**DECISION DELEGATED TO HEAD OF PLANNING**

**Application No:** H09-0473-25                      **Applicant:** Mr M Rumble

**Proposal:** Demolition of existing derelict dwelling & erection of detached 3 bed self build dwelling

**Location:** The Poplars Chapel Drove Holbeach Drove

front elevation  
1:100

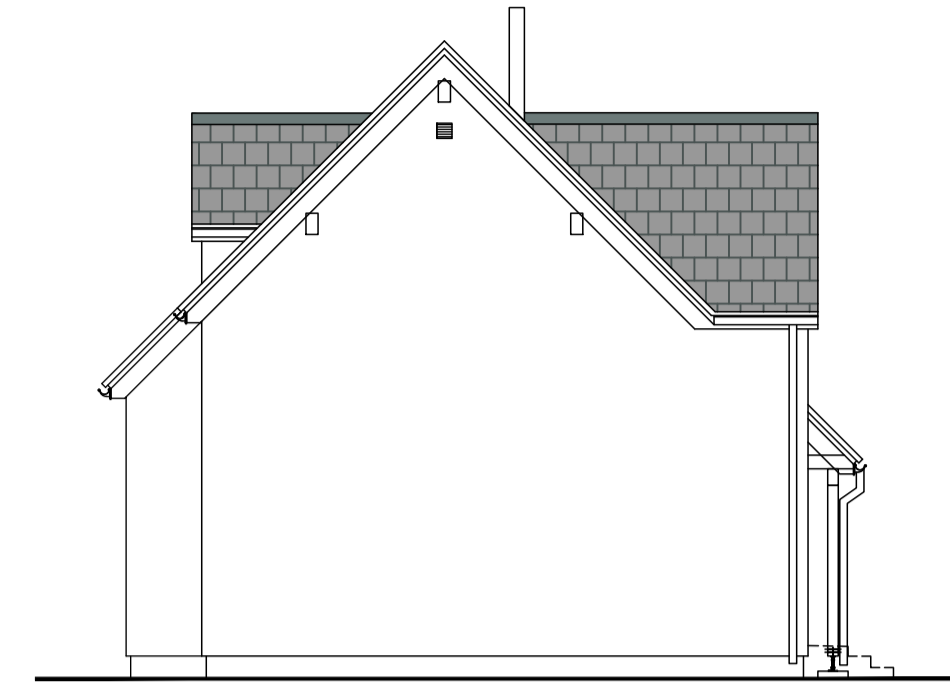
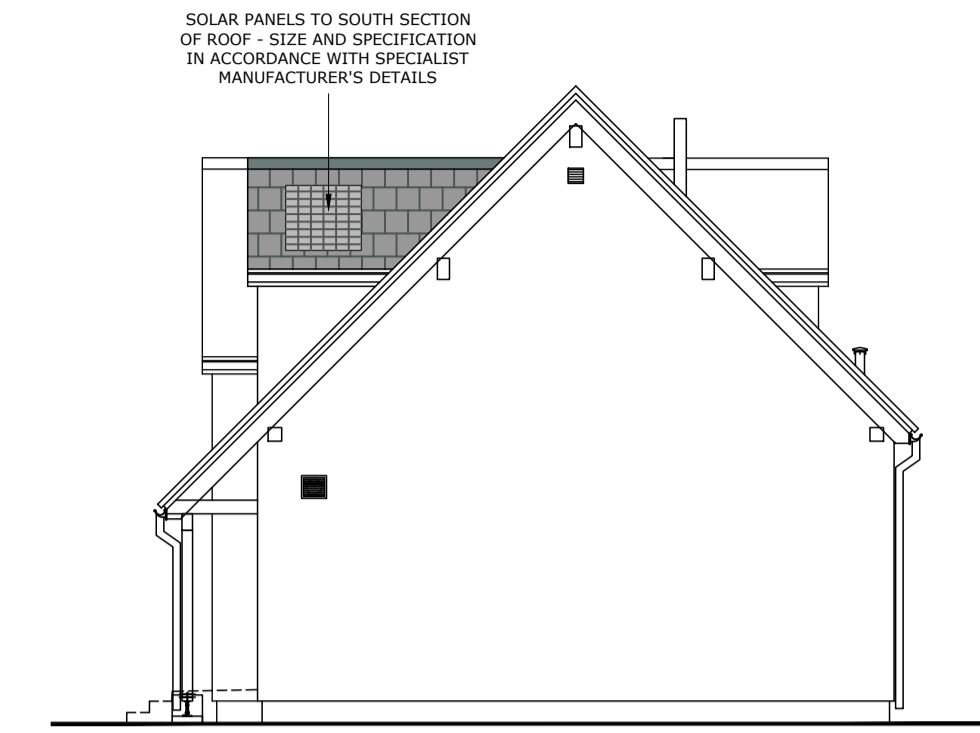
4 - The replacement dwelling is not considered to be of a high standard in terms of architectural detailing and materials of construction. The design itself is atypical, with a severely sloping roof along the principal elevation which appears unsightly and alien. The dormer windows are also fairly irregular due to their increased height and the low positioning of the windows. There are no additions which are of high architectural detailing when assessing the elevational plans which have been provided. Solar panels are proposed, albeit these are only on the rear and side of the dormer window and would not be visible from the highway to warrant a high standard of architectural detailing.

Alongside this, the materials that are proposed are also typical and as such are not of a high standard. The proposed use of white render for the walls, Marley modern roof tiles, white uPVC windows and gutters are conventional and would not appear out of character in a conventional modern estate. This typicality prevents the proposal from achieving the high quality of design/material selection required under criterion 4.

As outlined previously, the roof slope and dormer windows are both atypical features, which provide an unevenness to the appearance of the dwelling. The gable ended forward projecting element contrasts with the wider design, reducing the symmetry of the dwelling whilst also clashing with the low eaves height, creating an unattractive frontage. Whilst this may be comparably an improvement over the existing derelict site, the provisions of Policy 22 of the SELLP, which this application must be judged in context of due to its nature as a replacement dwelling, requires a high quality design, as opposed to merely an improvement.

block plan
1:500

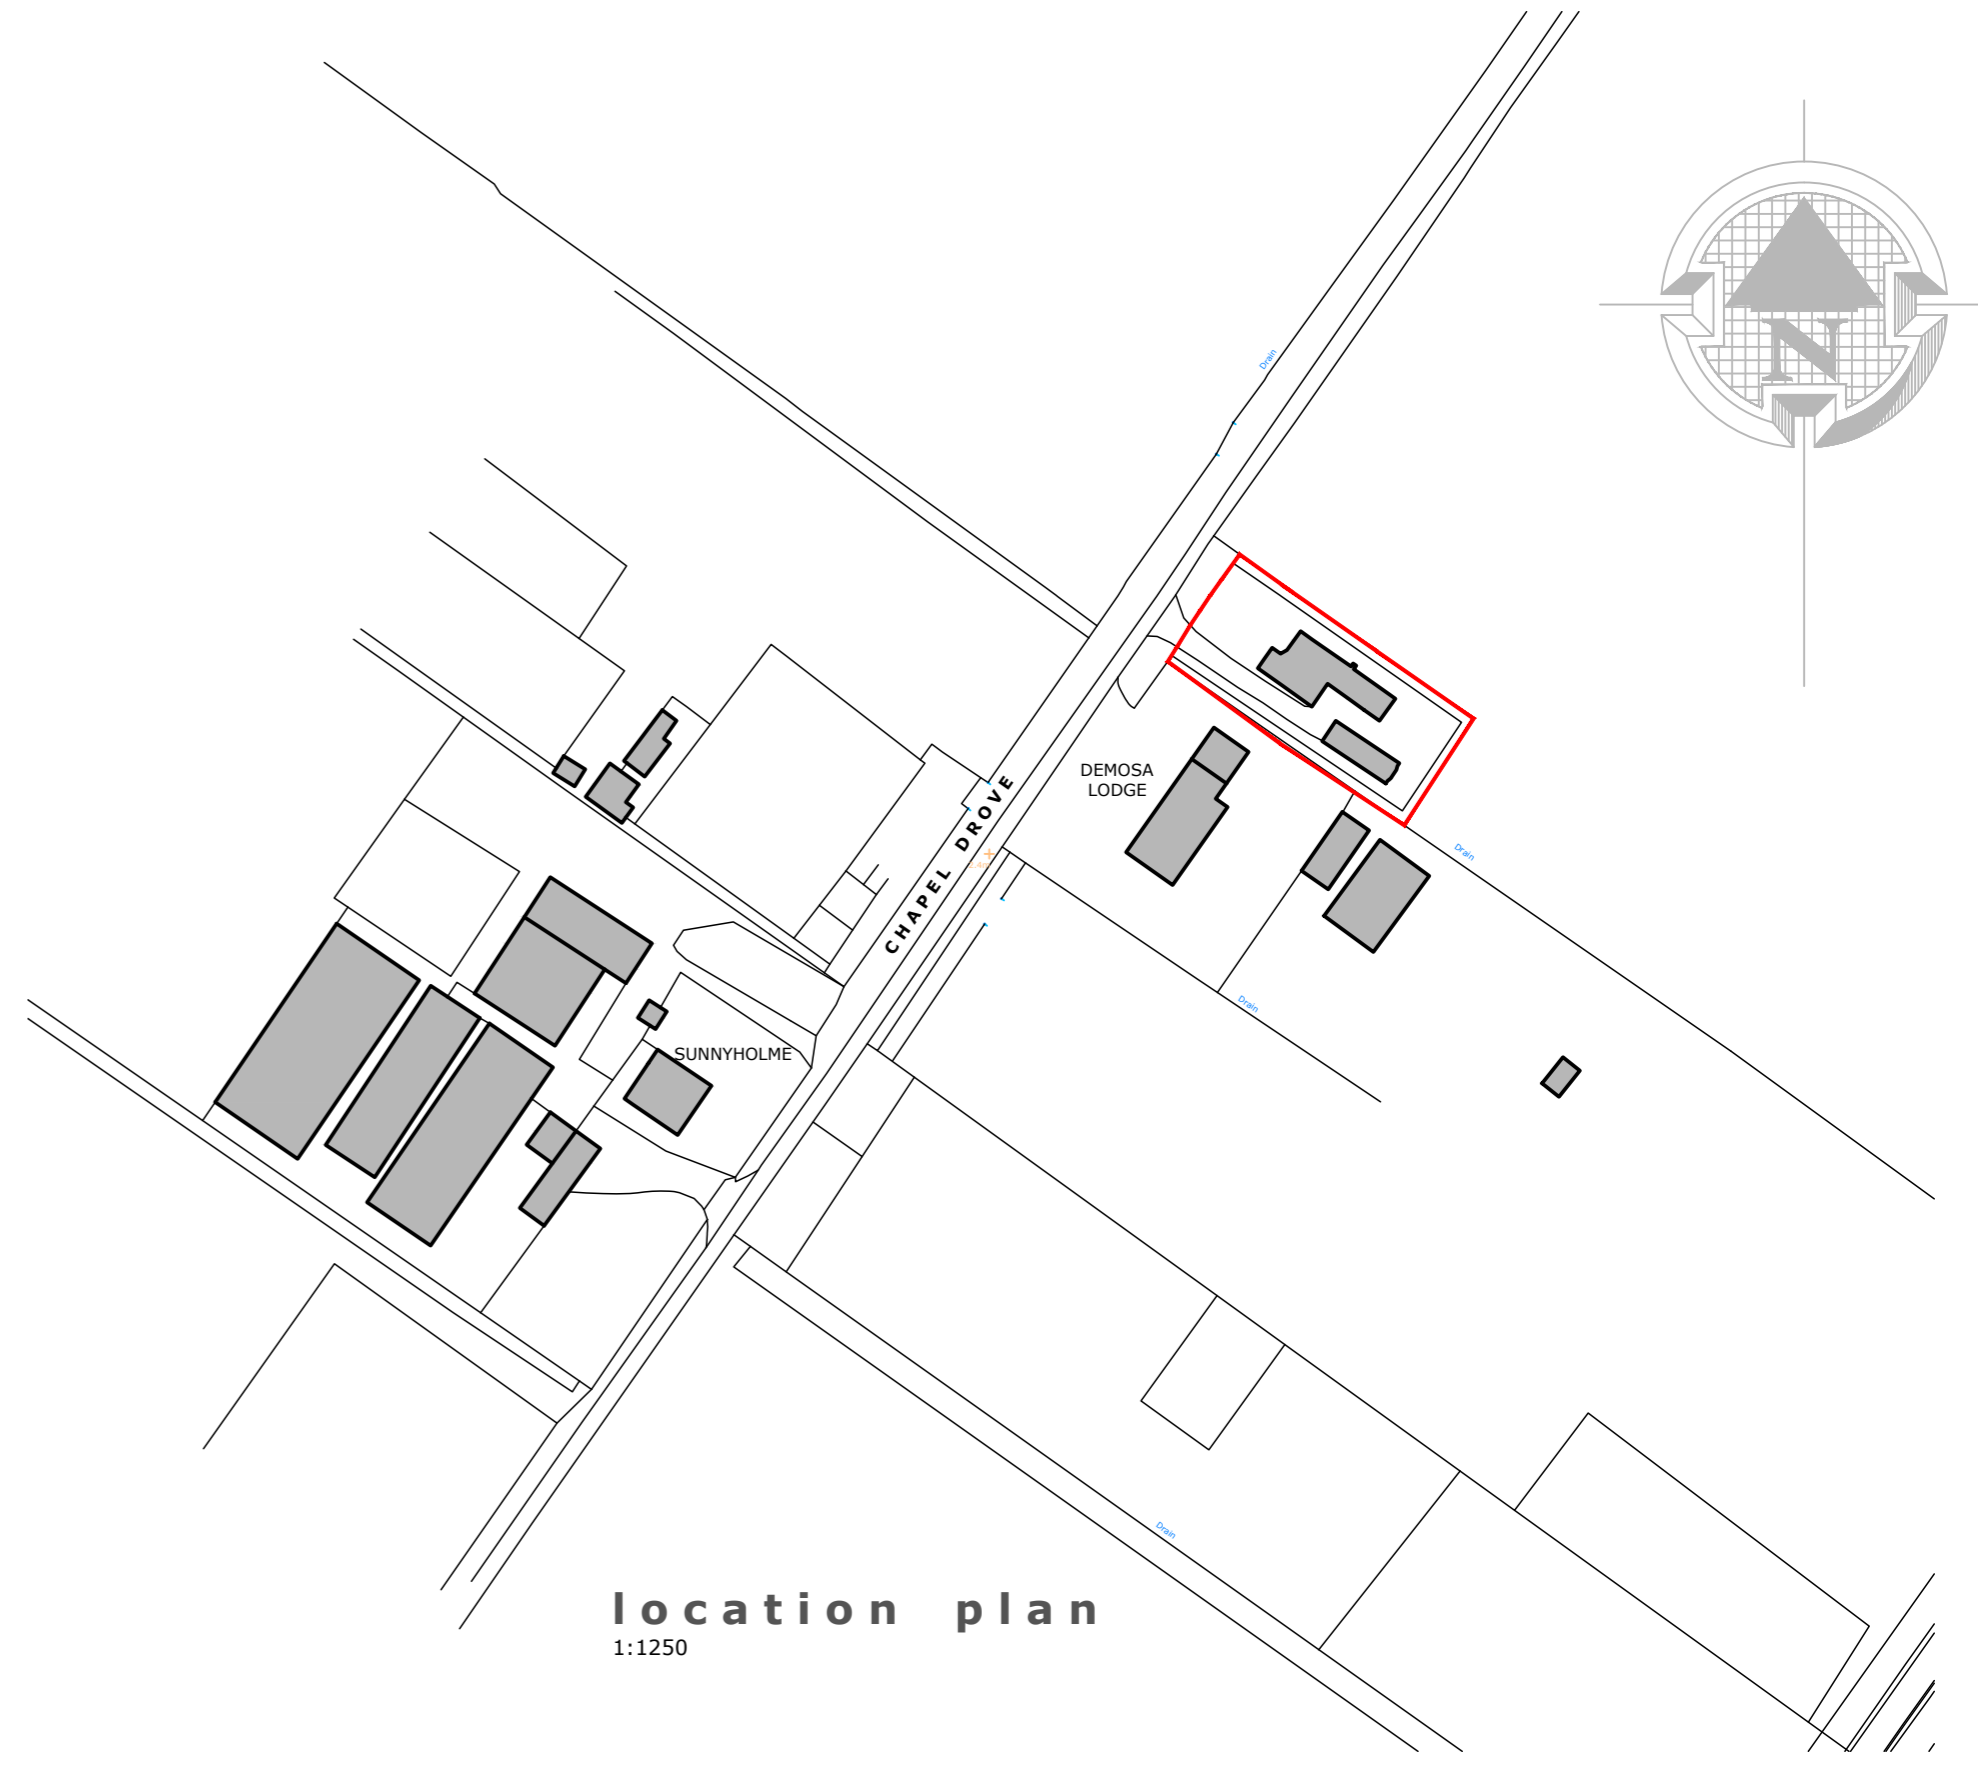
Additional information required - "The access needs to be upgraded to Lincolnshire County Council Specification and a note should be added to the proposed site plan".

The Highway Authority has requested that a note be added, requiring the access to be upgraded to LCC specification. Due to the unacceptable principle of the dwelling, this amendment has not been sought. However, beyond this, the proposal is not considered to have an unacceptable adverse impact upon the highway network or safety.
